# **SSD 17\_8665 THE MERCANTILE HOTEL**

## **RESPONSE TO SUBMISSIONS**

2 APRIL 2019  
SA6771  
FINAL  
PREPARED FOR HBMS NSW PTY LTD

Drawing Title
Proposed Roof Terrace Plan

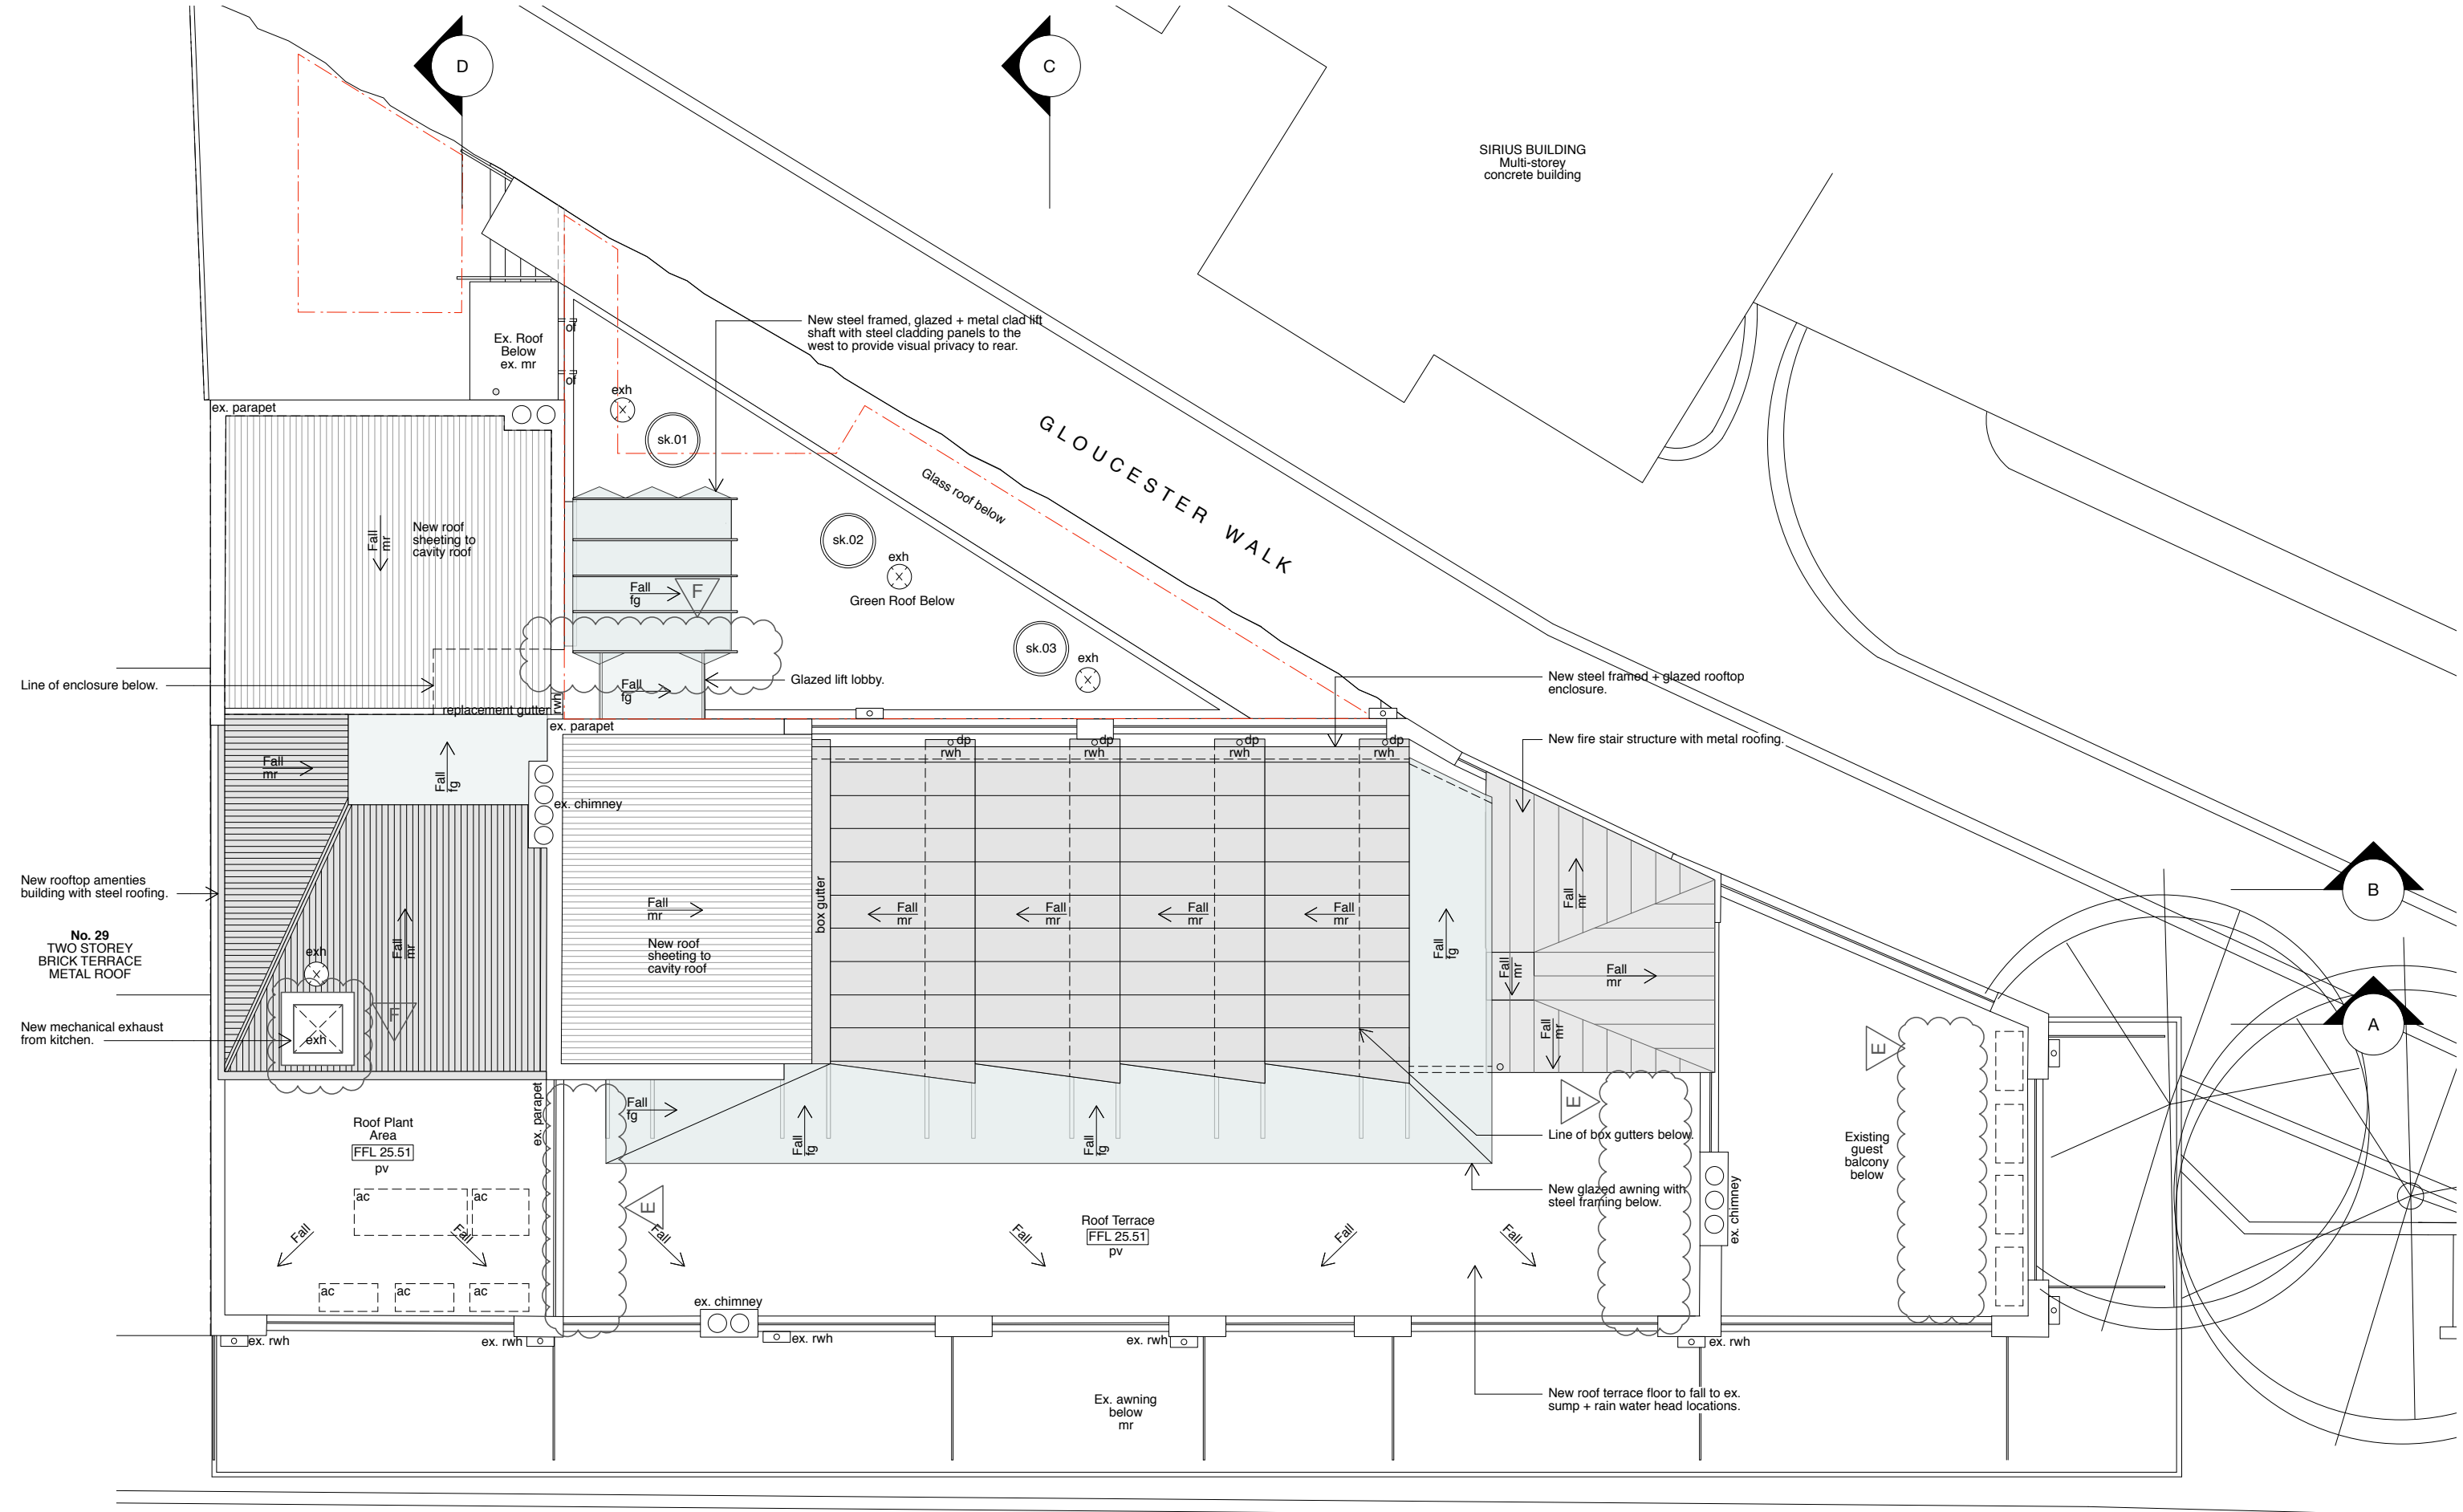
Issue	Comment	Response	Refer to
4. Design	Give consideration to the removal of the roof terrace planter beds and plants.	<ul style="list-style-type: none"> <li>All 'freestanding' planters have been removed. Planters at the rear of the building (at the western end of the rooftop level) have been retained for privacy reasons.</li> </ul>	Appendix A

Rooftop Bar Plan
Scale: 1:100

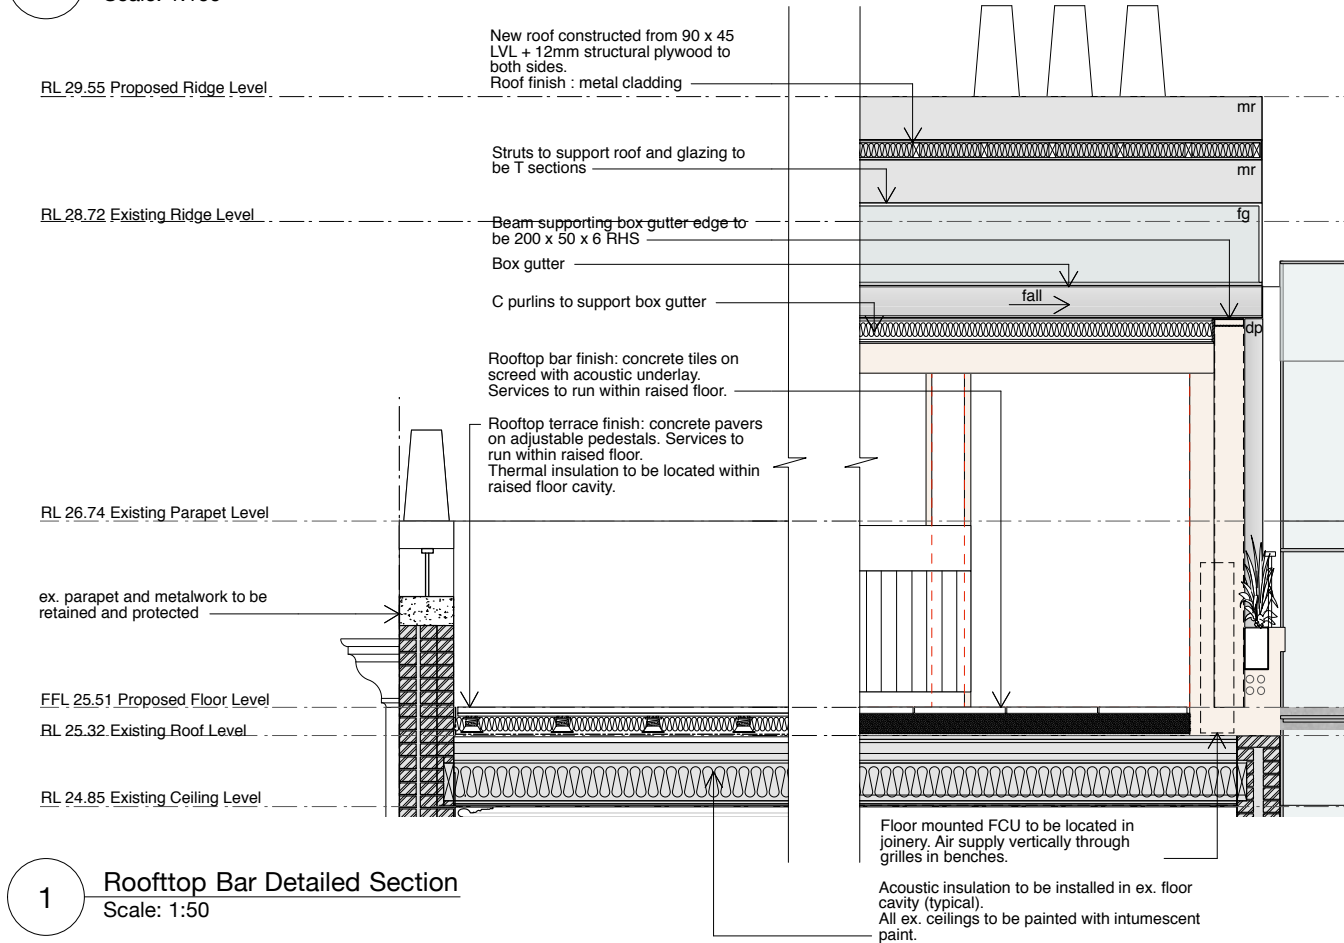
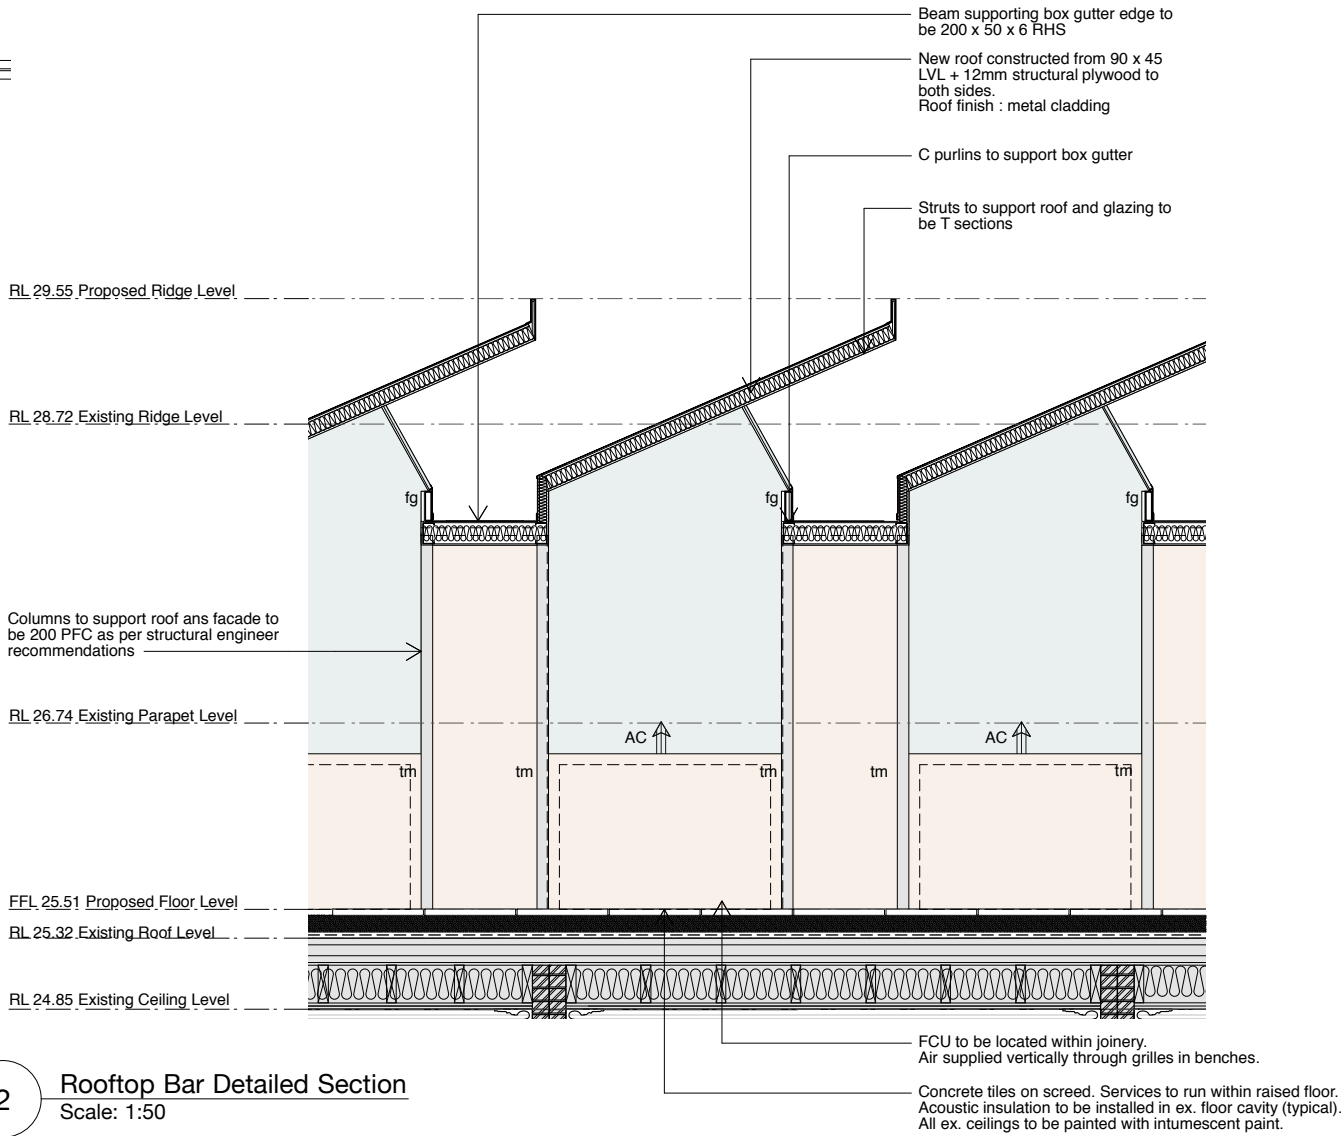
15. Heritage	Submit further information in relation to: <ul style="list-style-type: none"> <li>details of new walls, in order to confirm the capacity of timber floors to support them</li> <li>detailed sections of the proposed ensuite 'pods'</li> <li>roof floor levels, roof floor structure, stormwater drainage and trafficable surfaces will be resolved</li> <li>impacts on existing plaster decoration and timber joinery.</li> </ul>	<ul style="list-style-type: none"> <li>1:50 sections have been prepared by Welsh + Major Architects addressing these comments.</li> <li>Urbis Heritage has provided a detailed response to impacts upon plaster decoration and timber joinery at Section 2.5 of the revised HIS.</li> </ul>	Appendix A and Appendix C
